Addendum #1

**Peoples Regional Opportunity Program
Phase III Scattered Site Affordable Housing
Anderson & Cumberland Streets, Portland, Maine 04101
North Street, Westbrook, Maine 04101**

January 28, 2005

A2.3

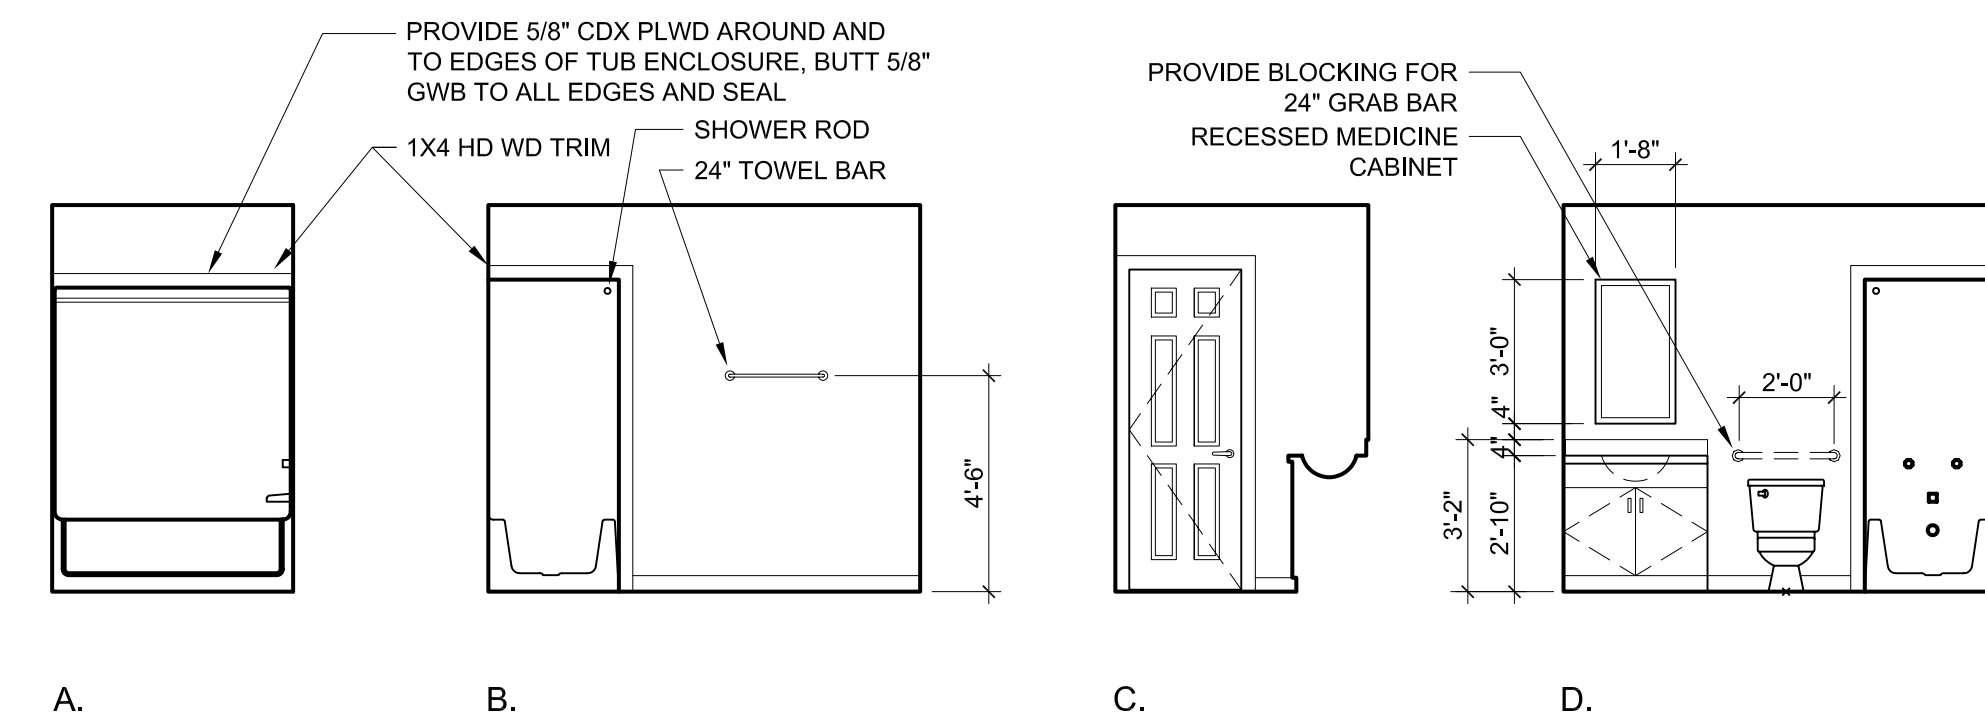
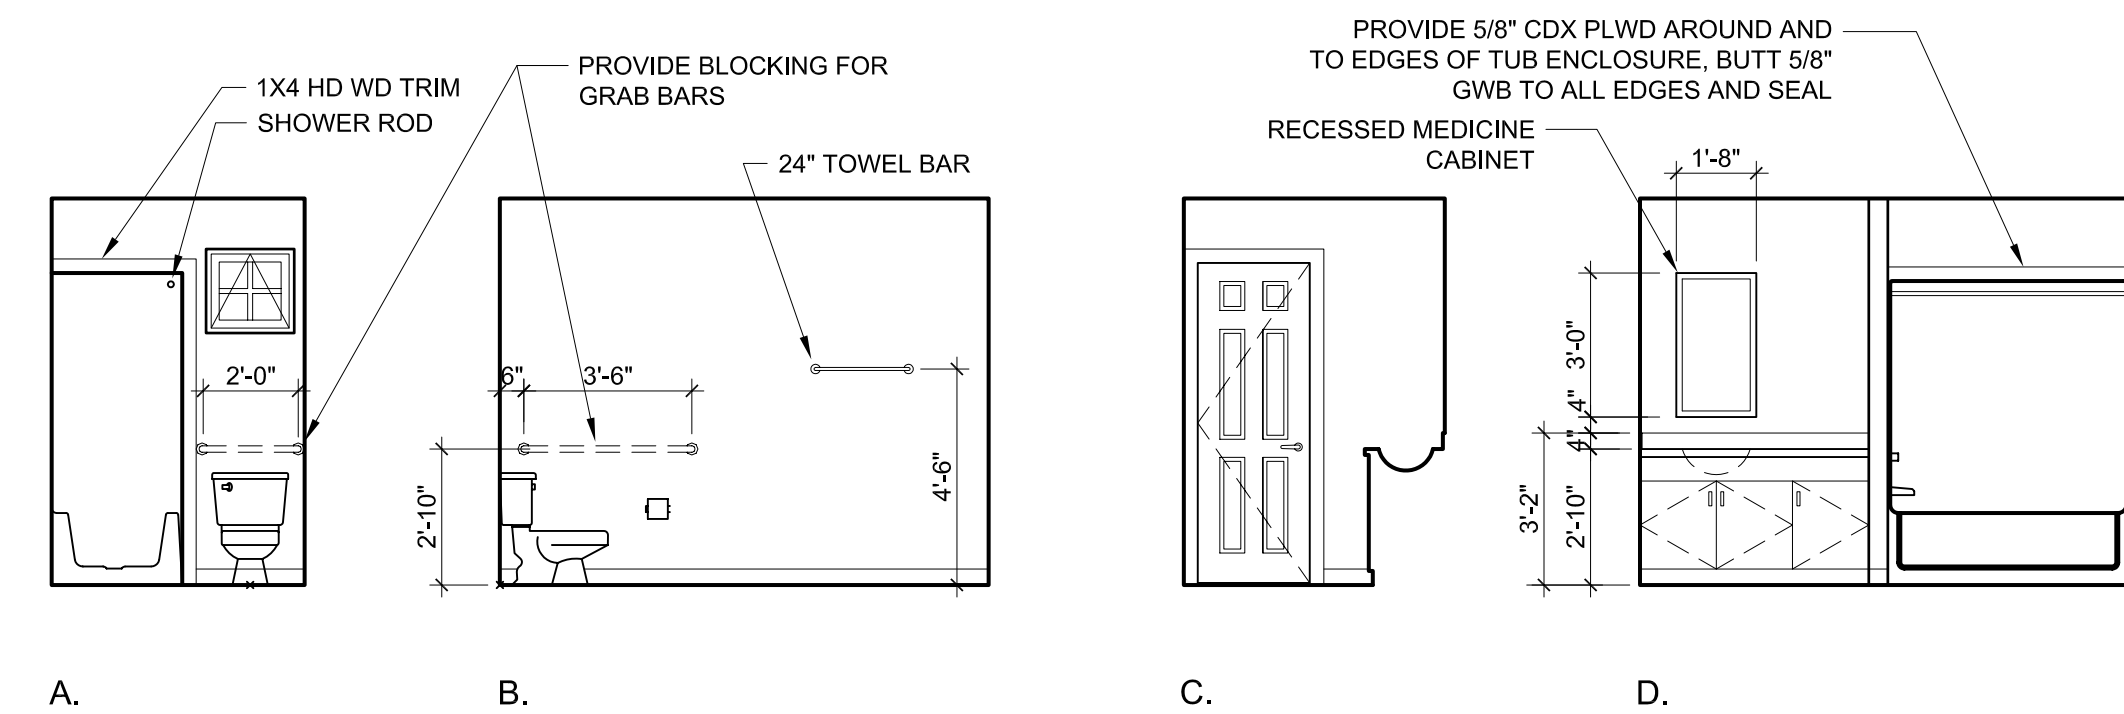
1-24	A1.0, A1.1, A1.2,		All sites Add note 11 for underlay @ linoleum floors.
1-25	A.0, A1.1, A1.2,		All sites Add note 11 for underlay @ linoleum floors.
1-26	A2.3	3, 4	All sites Add soffits above upper cabinets for vent duct.
1-27	A4.0	Anderson 3,4	Add geotech fabric per Geotech reports
1-28	A4.0	15, 17 North St. 3,4	Add geotech fabric per Geotech reports
1-29	A1.0, A1.1, A1.2,		All sites General Finish notes - Add note 11 for underlay @ linoleum floors.
